**Consultation Response from KC,  
Trees**

**2023/93667 Storthes Hall Student Village, Storthes Hall Lane, Kirkburton, Huddersfield, HD8  
0WA**

**Date Responded: 02/04/2025**

| PROJECT                                                               |  |  |  |  |  | CLIENT                      |          |             |      |
|-----------------------------------------------------------------------|--|--|--|--|--|-----------------------------|----------|-------------|------|
| PROPOSED SOUTHERN ACCESS ROAD LAYOUT - INCLUDING CARRIAGEWAY WIDENING |  |  |  |  |  | MEW                         | MEW      | 18092/GA/06 |      |

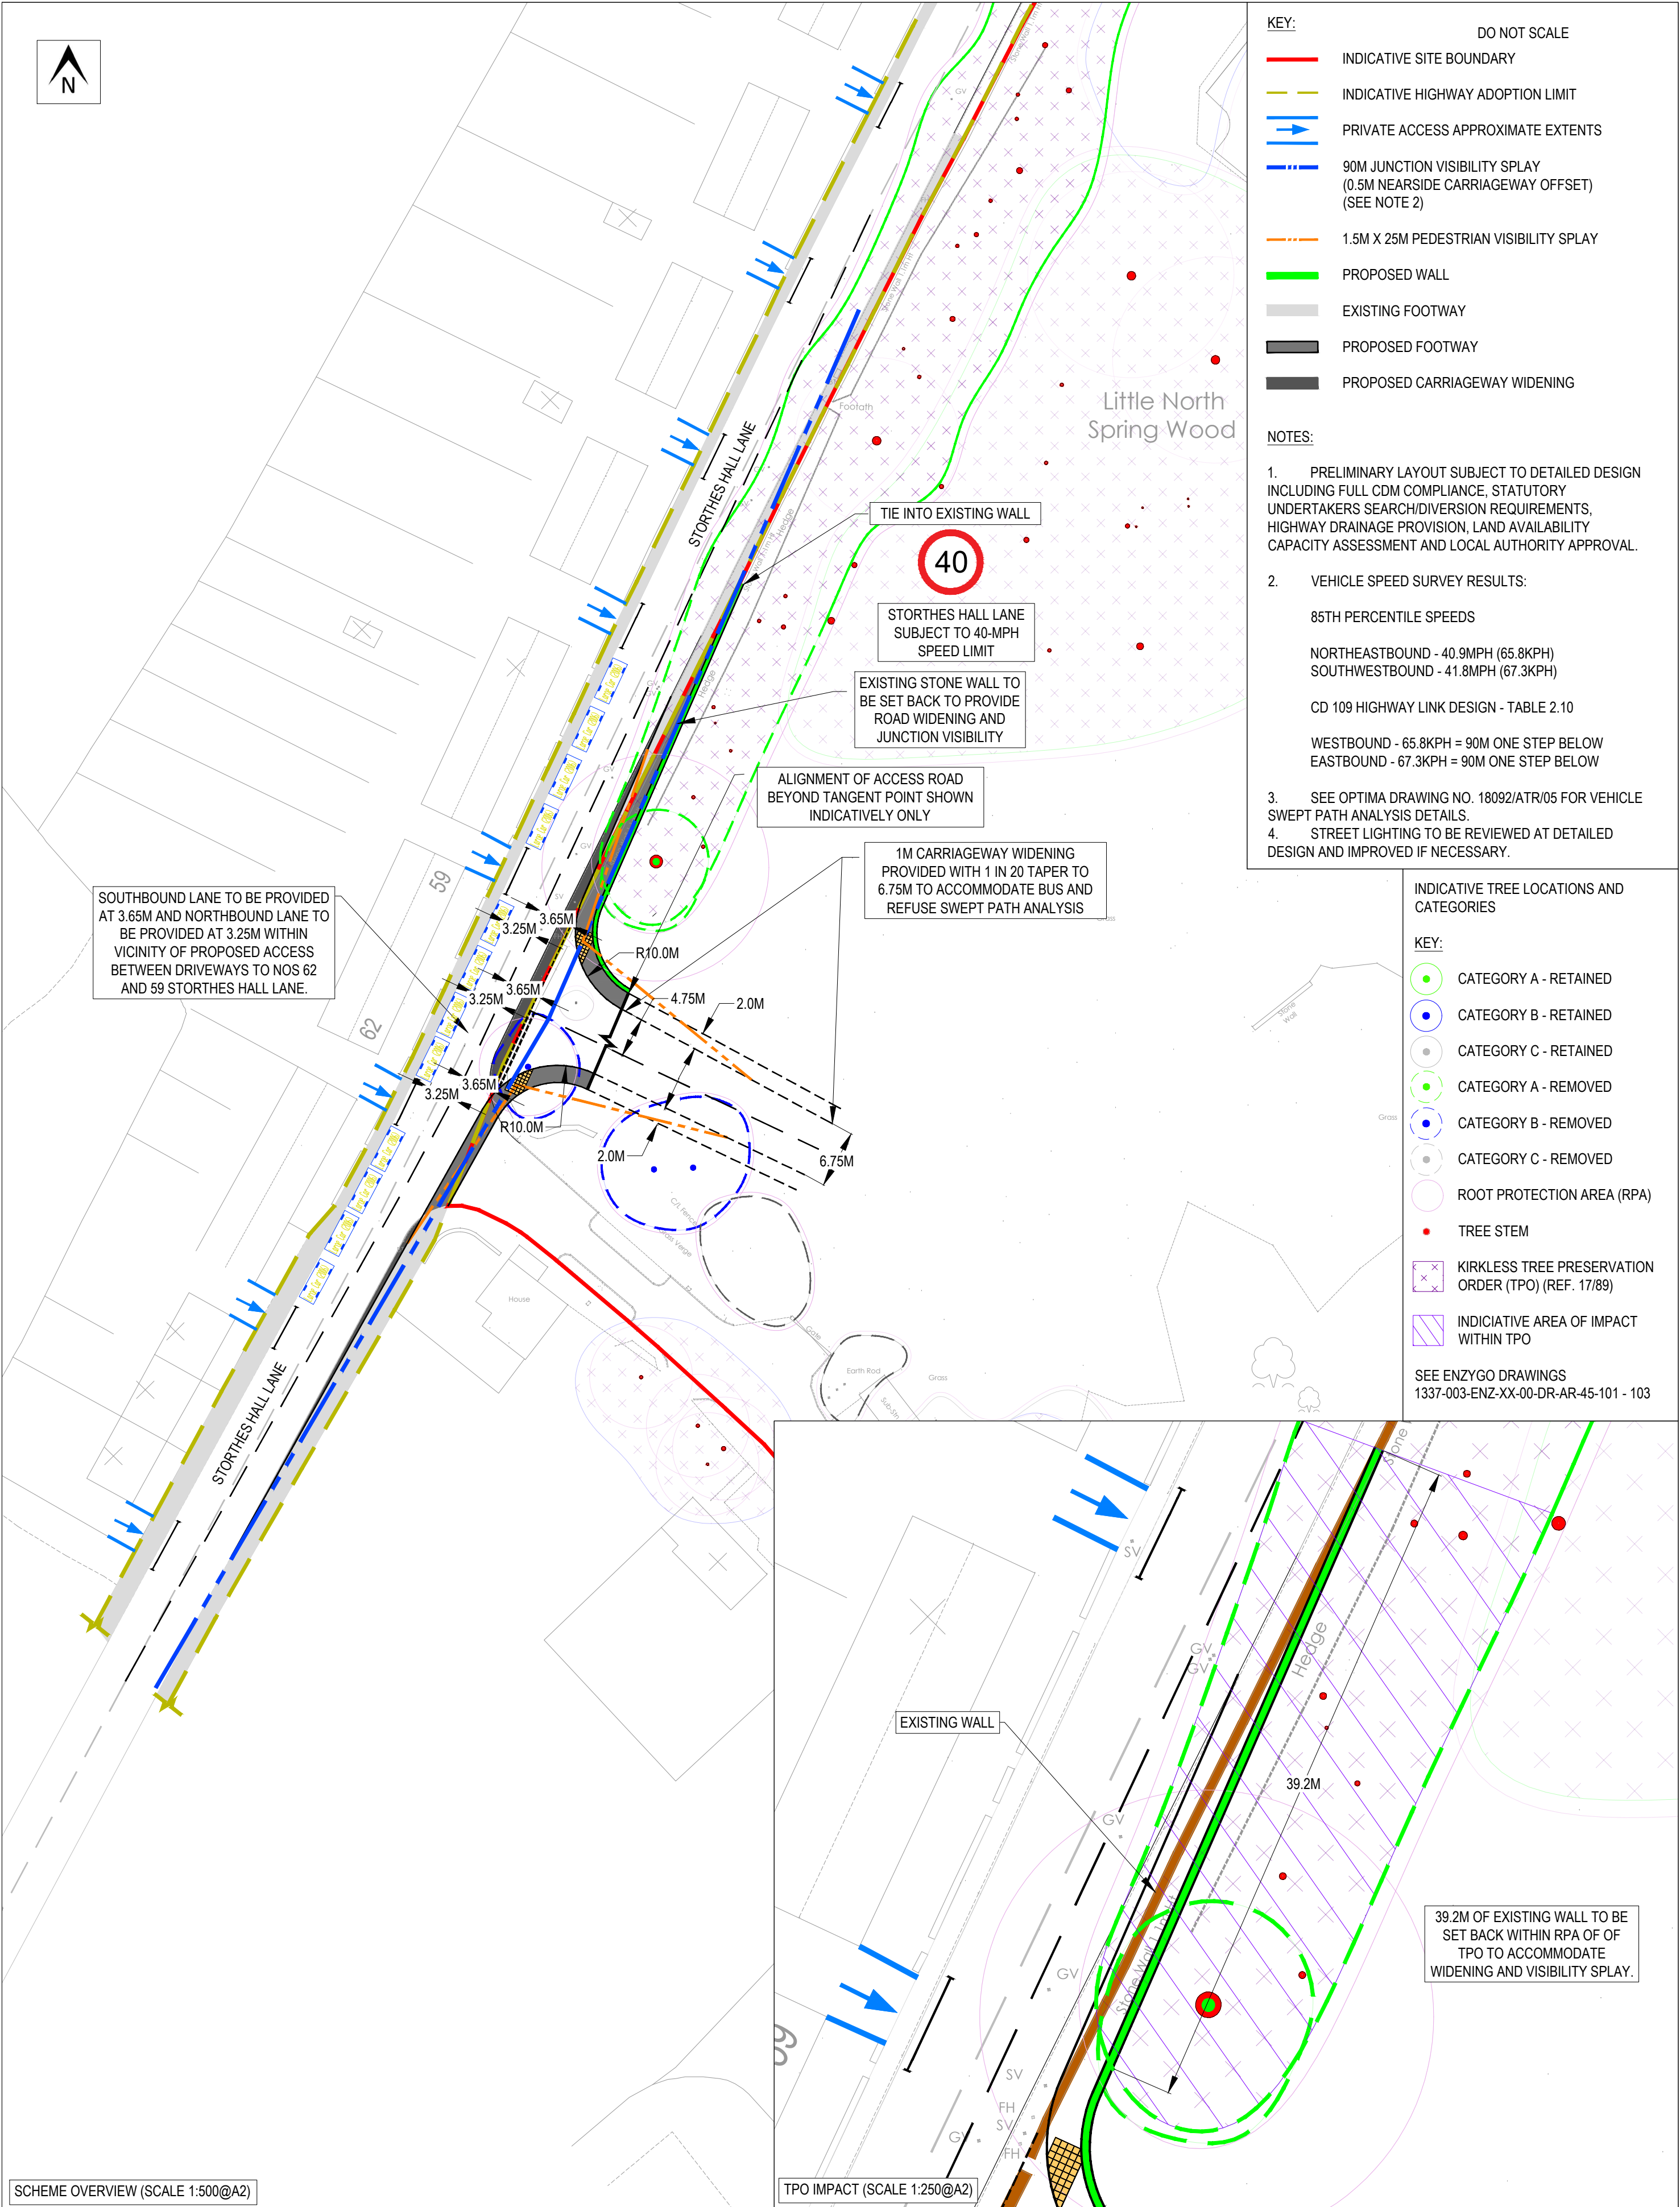
The most recently submitted plans for the amended location of the Southern access will result in more tree loss. After reviewing Iain Tavendales AIA which specifically looks at this area, KC Trees believes the loss of T2 and G1/G2 to be tolerable when taking into consideration the mitigation planting proposed. The status of T1 is a category A tree and should be retained by any means possible. KC Trees is of the opinion that the tree can be retained with the potential of some root pruning to facilitate the new Access. Again, this should be carried out by the project arboriculturalist.
